MR & KM Hussey

5th August 2024

Pins Reference EN010137 Mona Offshore Wind farm
Interested Party Numbers MNOW-S57019 & MNOW-S57018

Figure 1.8: Daytime construction noise impact magnitudes: TJB and joint bay excavation

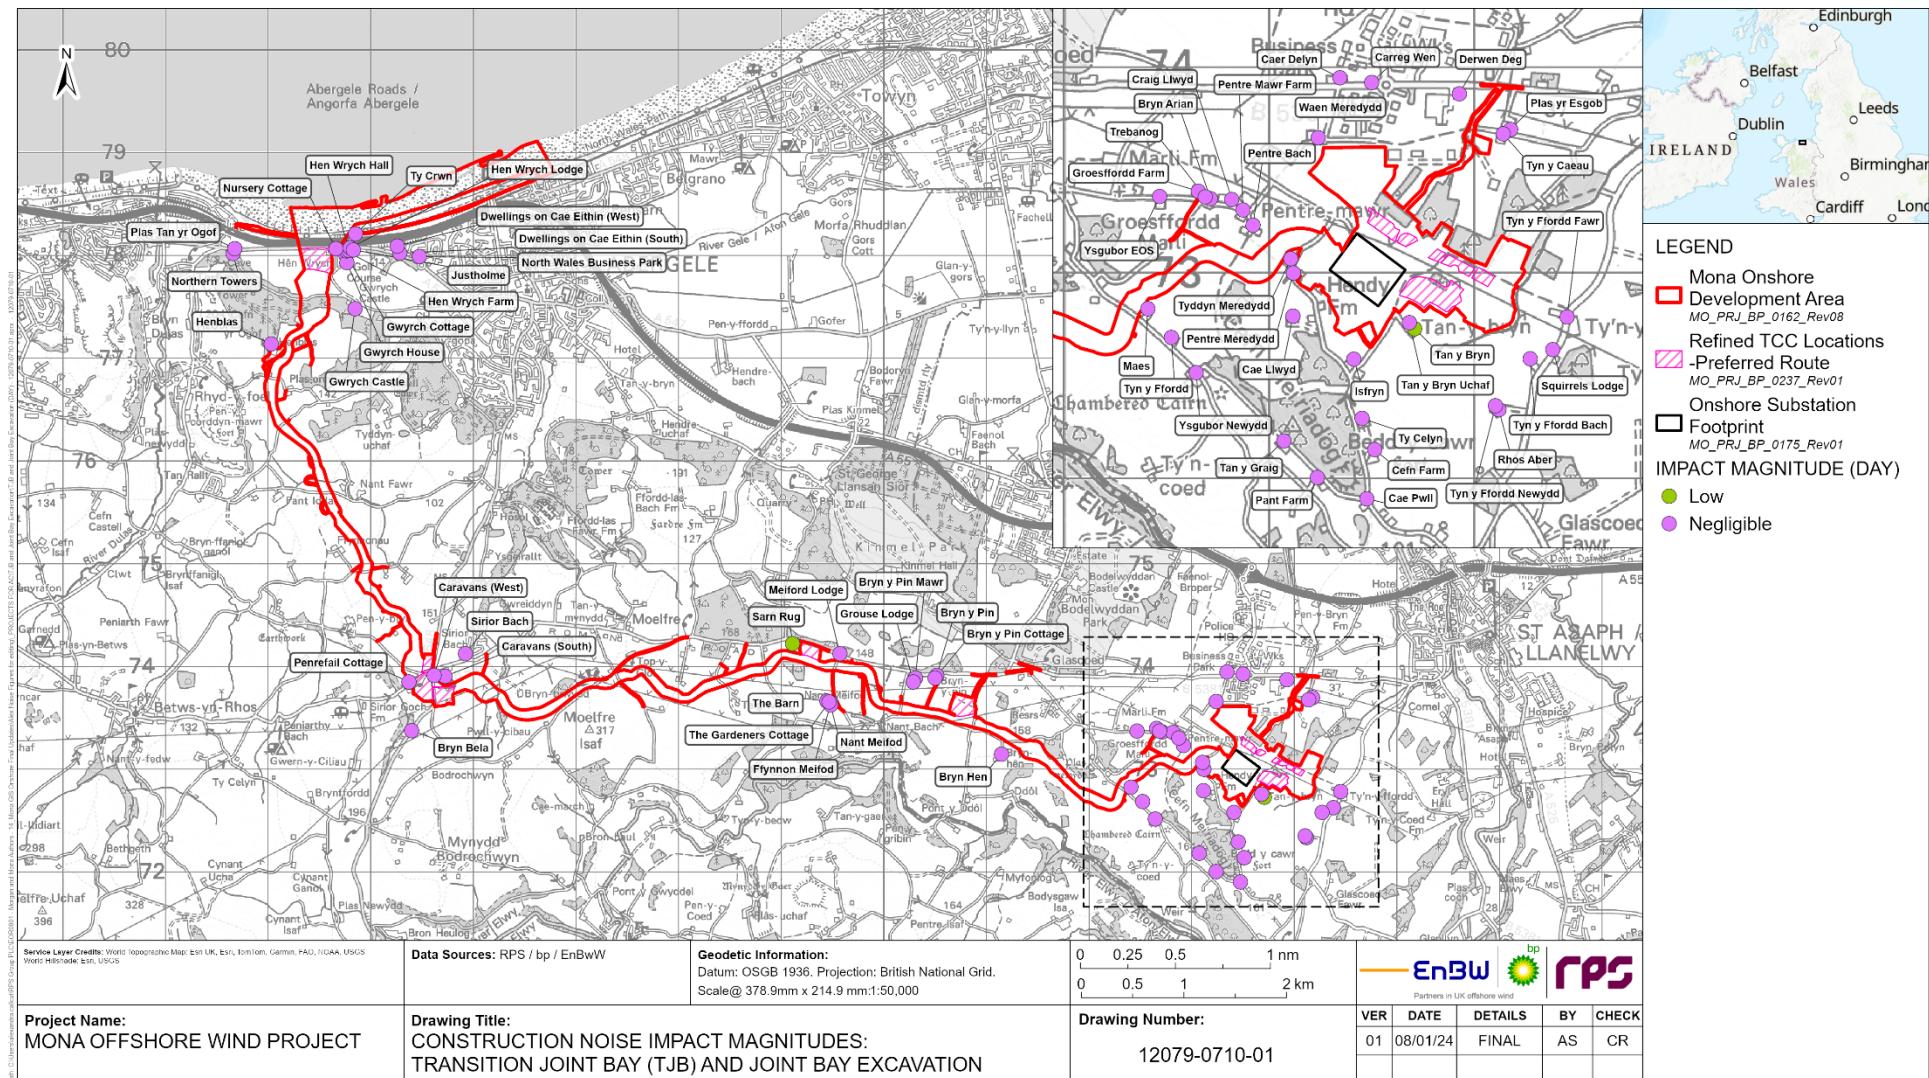
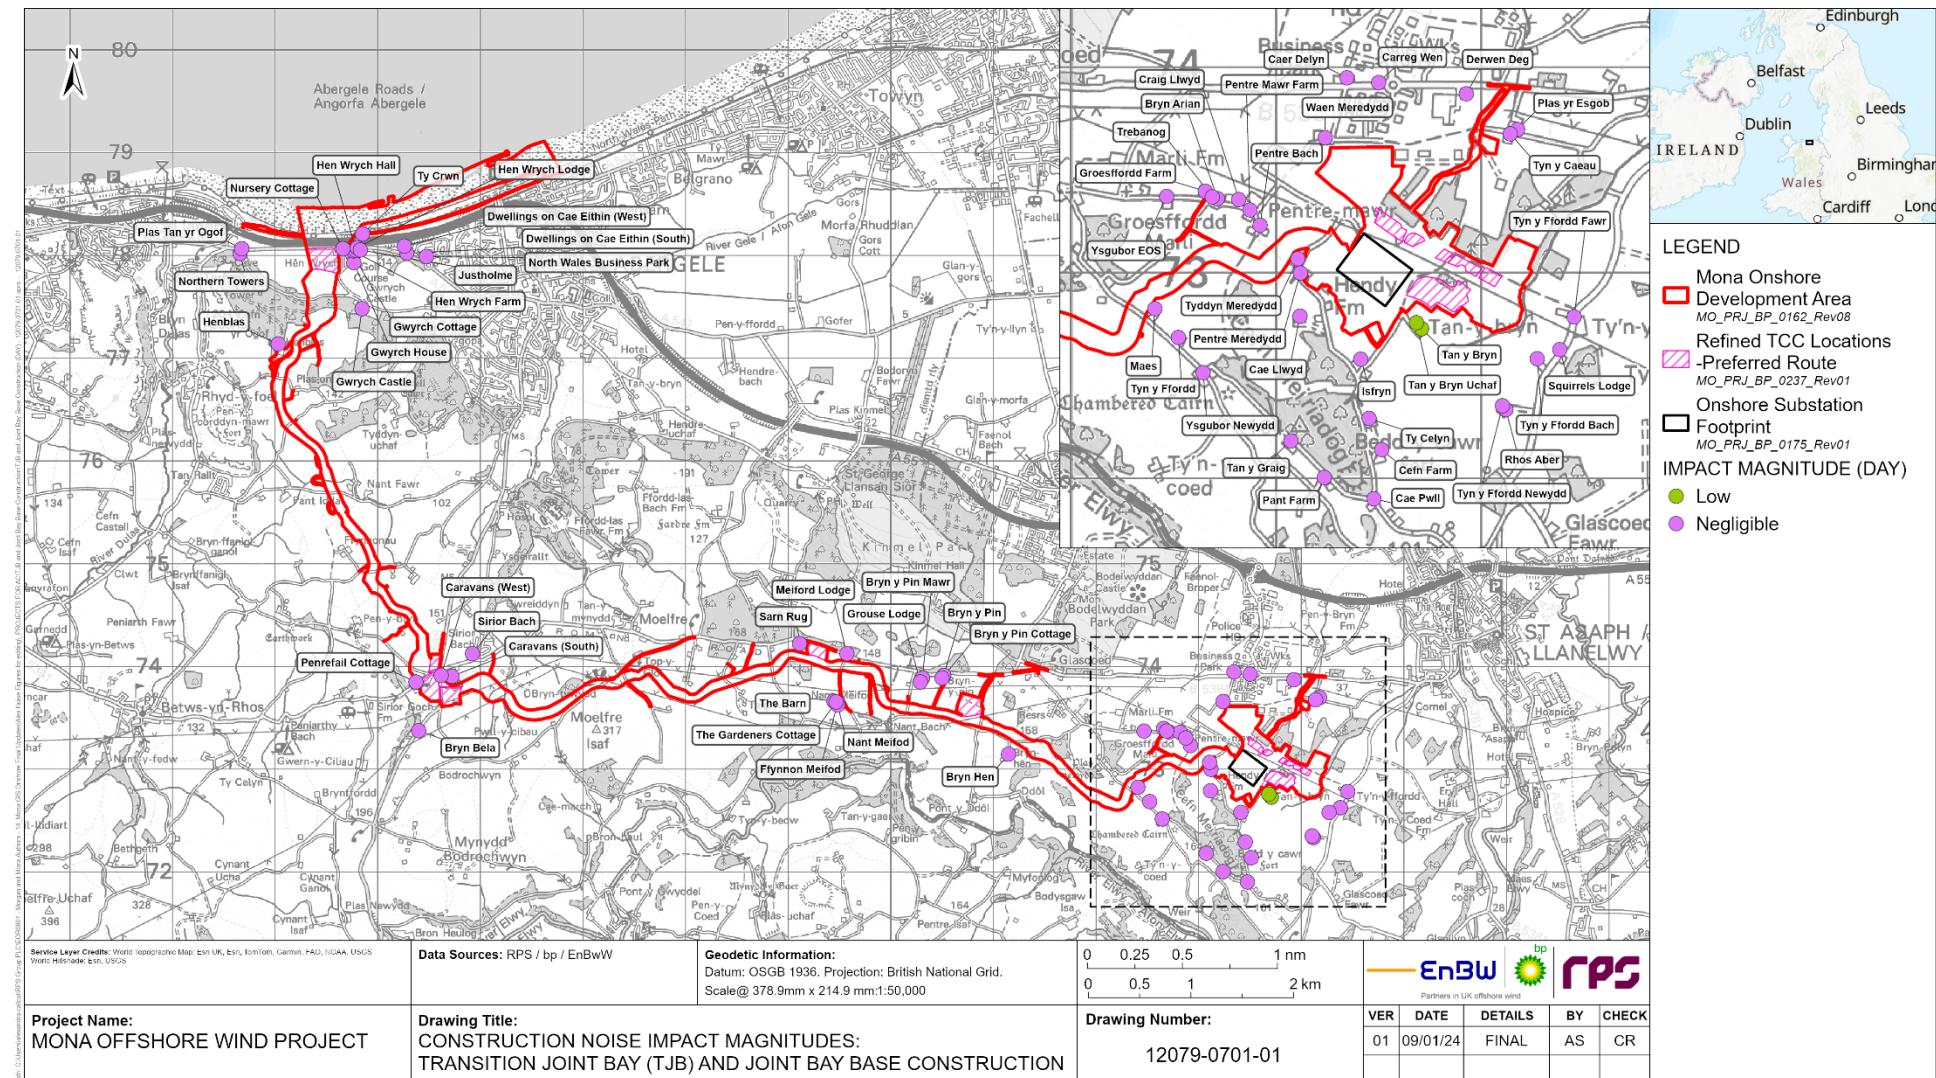
- The predicted figures quoted by the modelling appear remarkably low for some of the construction activities to what one might expect, for an e.g., transition joint bays excavation, base construction of between 33 and 39dB for Tyddyn Meredydd would imply on the face of it, that disturbance will be less than the current baseline. These

types of predicted dB figures are actually more what one might experience spending the day in the local library.

Figure 1.16: Daytime construction noise impact magnitudes: Use of trenchless techniques compound

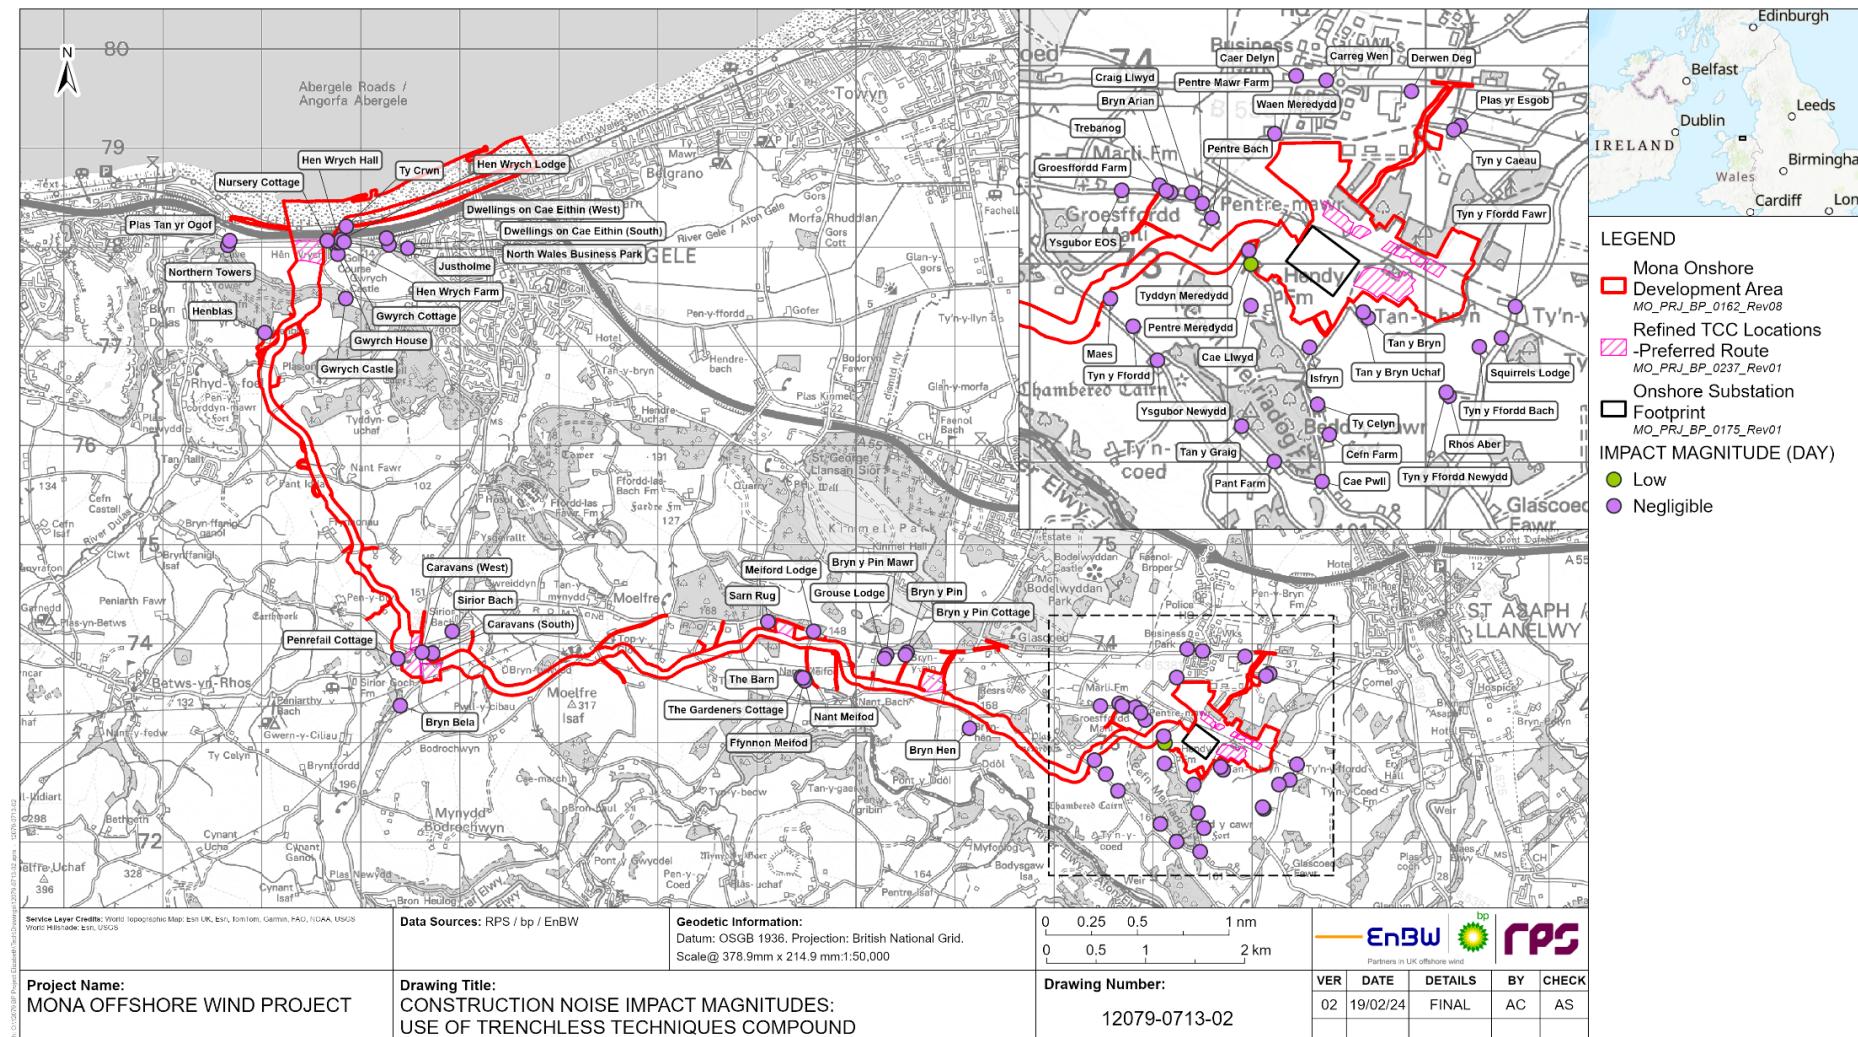
- For Trenchless Techniques the impact for Tyddyn Meredydd listed as Negligible whereas Pentre Meredydd is Low? It is difficult to see how Pentre Meredydd is closer to this activity and so it is hard to understand why there is any difference.

Figure 1.19: Daytime construction noise impact magnitudes: Substation groundworks

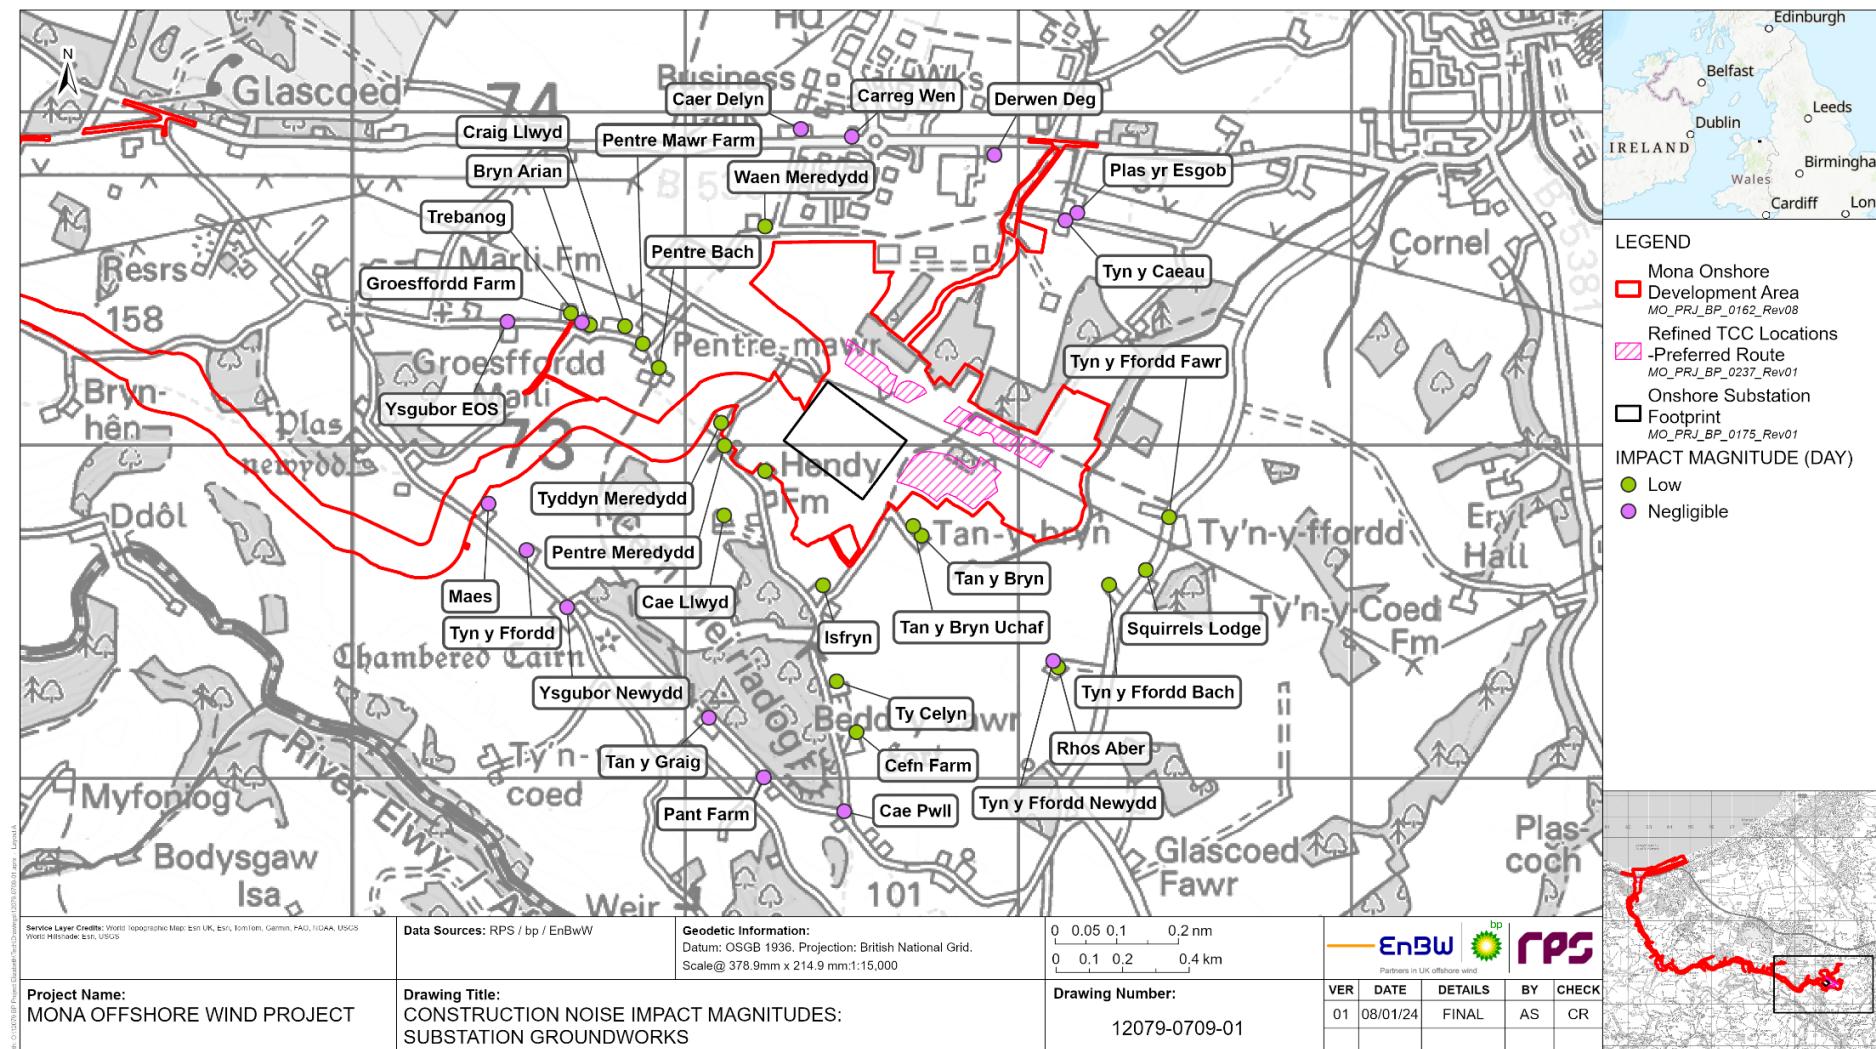
- APP-179 F7.9.2 Appendix B lists impacts by specific construction activity:-
 - For Substation ground works it appears that the closer you are to the work then the quieter it will be? For e.g., we have a predicted noise level impact of 23dB whereas Pentre Mawr farm and Ysgubor EOS, both much further away have 39dB and 51dB noise impact levels respectively.
